Champions Quarry Expansion

MODIFICATION 2 RESPONSE TO SUBMISSIONS 2016 (APRIL 2016)

CHAMPIONS QUARRY RESPONSE TO SUBMISSIONS (APRIL 2016)

**Figure 3: Approved Conceptual Biodiversity Offset Areas and Protected Revegetation Areas**

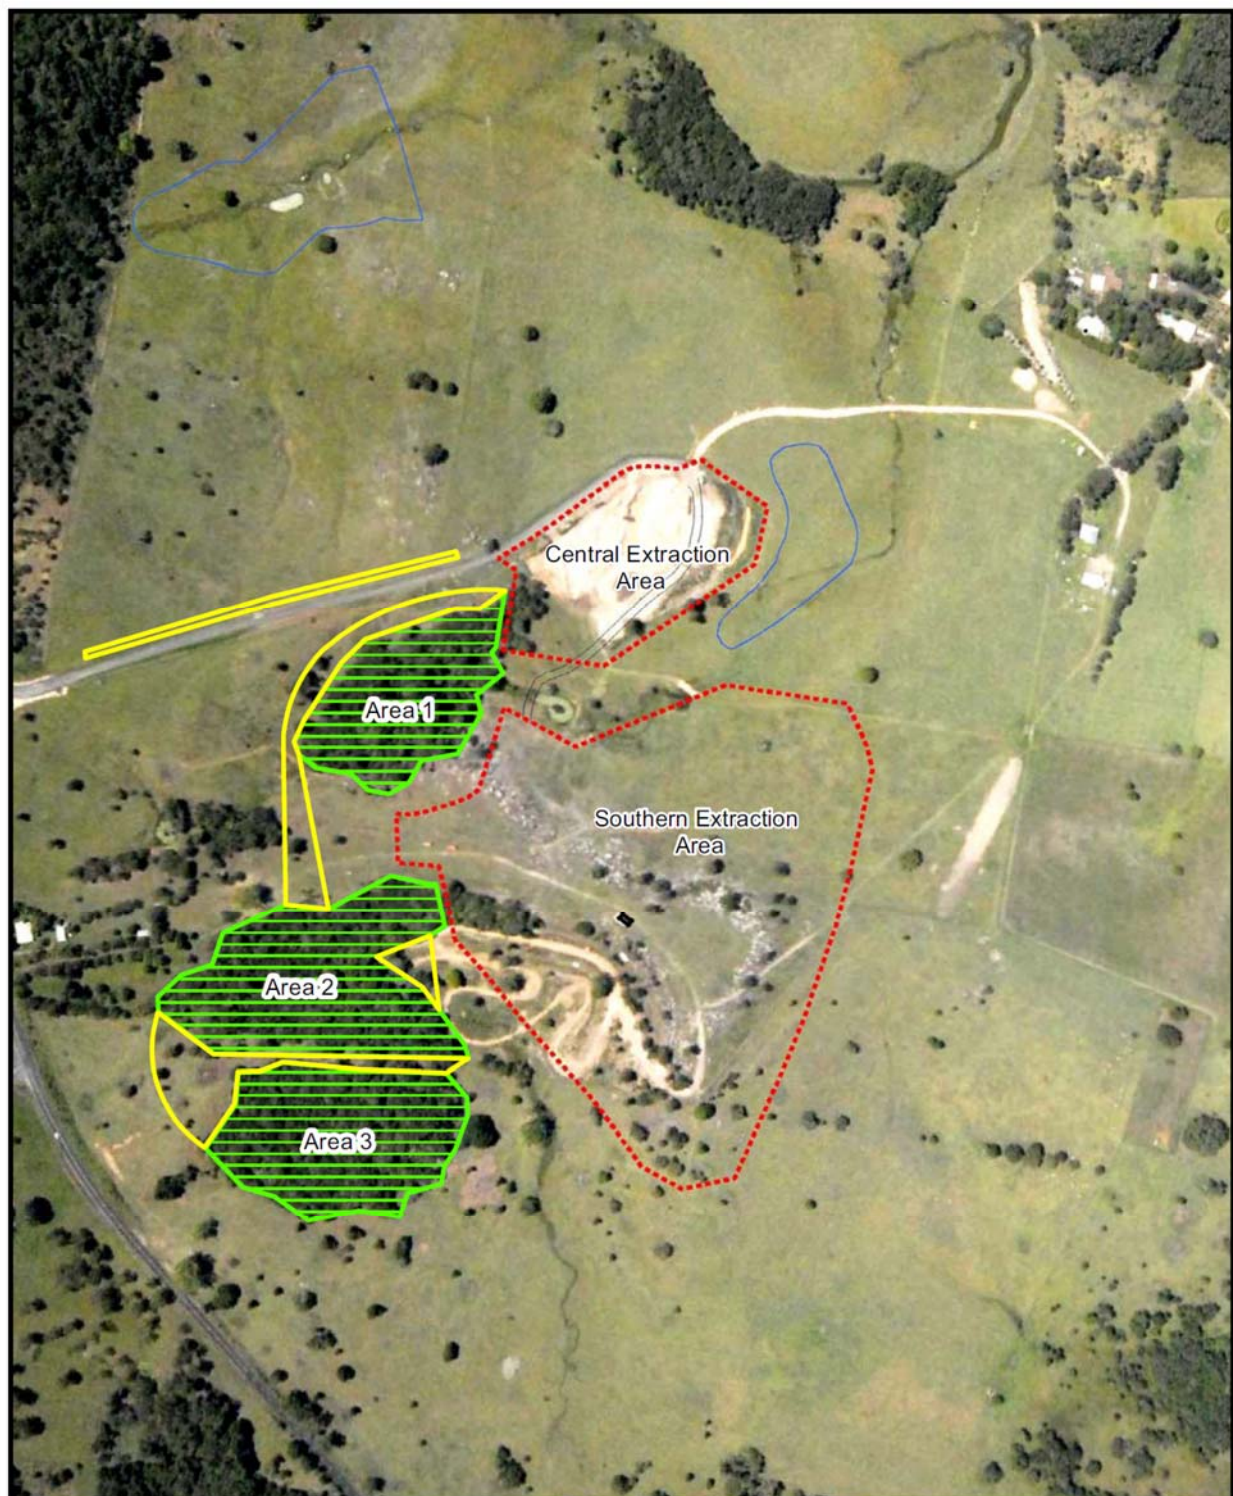
6.	Construction of a dam and other earthworks is in proximity to biodiversity offset areas. Review of the aerial photograph shows a dam has been constructed between the biodiversity offset areas 1 and 2 in a location that appears to be the currently approved location for one of the protected revegetation areas.

7.	Demonstrate, through noting on a figure of the size in hectares, that the area of the revised biodiversity offsets and protected revegetation area satisfies the minimum size requirements specified in in Condition 40, Table 7.

21.	Object to modification to update Figure 9 in Appendix 6 of the Project Approval for the following reasons: • The removal of Protected Vegetation has been assessed multiple times during this quarry's multiple applications. • All conditions were put in place with good reason. • Removing protected vegetation should not be permitted.	Previous assessment of the biodiversity off set areas and the protected revegetation areas were based on now out of date aerial imagery and had not been ground truthed. The proposed Figure has been ground truthed and is on a current aerial overlay. The only area removed from the Figure is the tree planting to the north of the main access road which was an error in the original plan. The figure exceeds all the minimum required areas as set out in Schedule 3, Condition 40 of the Project Approval.

– to meet the requirements of quarry traffic and meet this consent condition.	
25.	Object to modification to update Figure 9 in Appendix 6 of the Project Approval for the following reasons: - Existence of a new body of water that is in part of Area 2 that was not present in the previous map. Is that new water storage a part of this modification application? - If the vegetation planting on the north side of the access road is removed from protection of the current condition, will the department provide a suitable condition to protect that area from removal?	- Refer to item 6. - Part of the retention dam is located on the edge of the Protected Revegetation Area, not Area 2. - The tree planting to the north of the main access road was never proposed to form part of the final rehabilitated landform as set out in the Landscape Management Plan. The area is required to be maintained during the operation of the quarry in accordance with the Landscape Management Plan.. Refer to item 22.

31.	Object to modification to update Figure 9 in Appendix 6 of the Project Approval for the following reasons: • The area of vegetation north of the access road from must be protected. The option requested by the proponents would provide the operators an opportunity to remove the plantings as desired once their obligation to ensure they are planted, watered, fertilised etc is fulfilled. I am unaware of any condition that specifies the visual landscape plantings cannot be removed. • RCS Group Plan dated 17/2/16 shows what appears to be a body of	• Refer to item 6. • The tree planting to the north of the main access road was never proposed to form part of the final rehabilitated landform as set out in the Landscape Management Plan. The area is required to be maintained during the operation of the quarry in accordance with the Landscape Management Plan. • The extraction areas must be 50 metres from Area 1. The operational areas of the quarry are permitted to be within the 50 metre buffer. The access road is within the operational area.

water encroaching into an area of Protected Revegetation Area (Area 2). Also encroaching into the 50m buffer area near Area 1 is an access road and other earthworks. These appear to contravene the Director General's directions now that boundaries that have been "surveyed and ground truthed".

Please refer to Annexure E being the Surveyors plan of biodiversity offset areas dated 24 June 2014 noting the areas and revised plan SP15109-SP2 with the areas. Please refer to Annexure F being the revised Figure 9 in the Project Approval noting the total areas of the biodiversity offset areas.	Table 7 - Project Approval		Proposed Area	Area Offset	Minimum Size (ha)	Minimum Size (ha)	Area 1	1.71 ha	1.72 ha	Area 2	2.56 ha	2.659 ha	Area 3	2.14 ha	2.165 ha	Protected Revegetation Area	1.5 ha	1.653 ha	TOTAL	7.91 ha	8.197 ha
Table 7 - Project Approval		Proposed Area																					
Area Offset	Minimum Size (ha)	Minimum Size (ha)																					
Area 1	1.71 ha	1.72 ha																					
Area 2	2.56 ha	2.659 ha																					
Area 3	2.14 ha	2.165 ha																					
Protected Revegetation Area	1.5 ha	1.653 ha																					
TOTAL	7.91 ha	8.197 ha
